Re: Transportation Impact Study - Revised  
Haven Valley – Security-Widefield, Colorado

Aldridge Transportation Consultants (ATC) is pleased to present this Traffic Impact Study regarding the proposed development of Haven Valley in Security-Widefield.

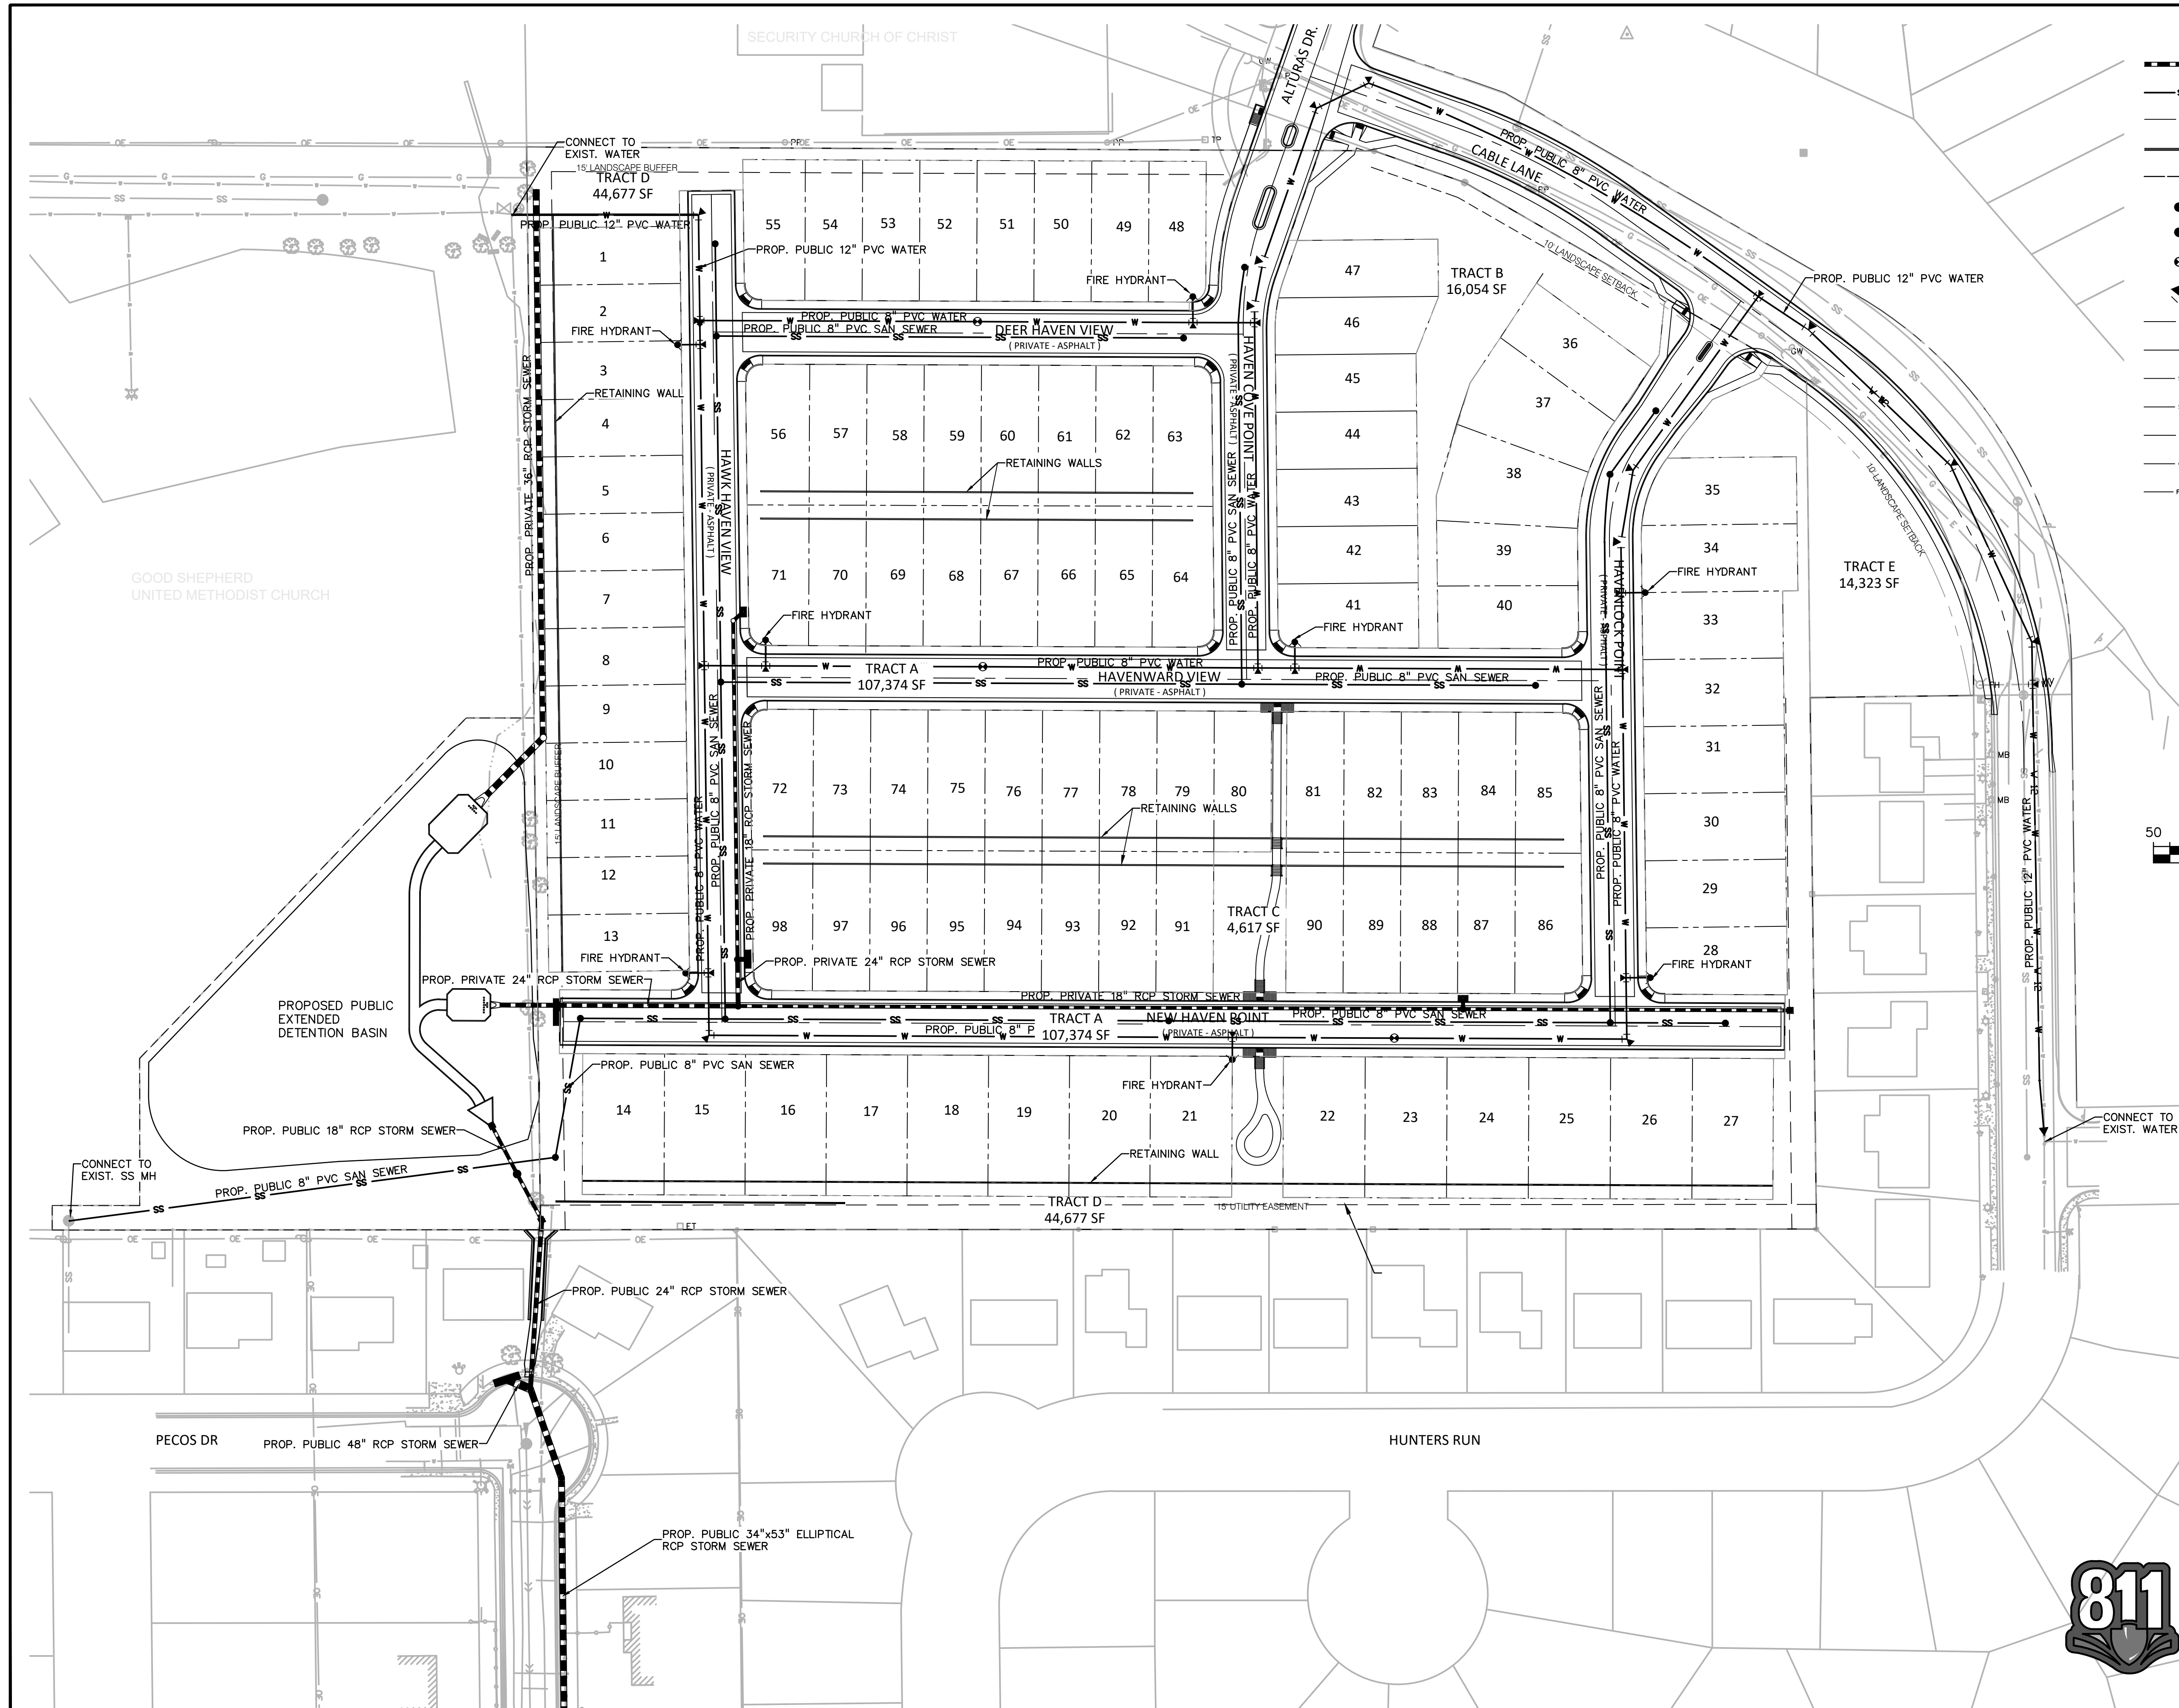
Per the cross section provided on the preliminary plan the internal streets match the urban local low volume cross section in the ECM which have a max design ADT of 300. Please coordinate with your project planner so that the proper roadway cross section(s) and roadway layout is provided on the preliminary plan. Please provide an exhibit showing which roadways are classified as urban local and which are urban local low volume.

Text revised and  
exhibits added.

The site plan indicates that Cable Lane will be reconstructed east from Alturas Dr. to Hunters Run match the cross-section of Hunters Run. The roadway improvement will include curb and gutter on both sides and attached sidewalks on the south side. The Haven Valley internal streets are classified as Urban Local Roadways with 50-foot right-of-way and 30 feet of pavement. They will be posted at 25 mph and have maximum capacity of 3,000 ADT which is more than adequate given that the entire development will generate less than 1,000 ADT. All internal intersections meet the 175-foot spacing requirements. The only sight distance issue is at Prospect Point and Cable Lane intersection. On 25 mph roadways, 280 feet is required. In the graphic below looking east from the intersection at 10 feet back of curb, this is currently compromised by a growth of trees and bushes. It is anticipated that the reconstruction of Cable Lane will require removal of the trees and when done the sight line will be available. Looking west the sight line is available.
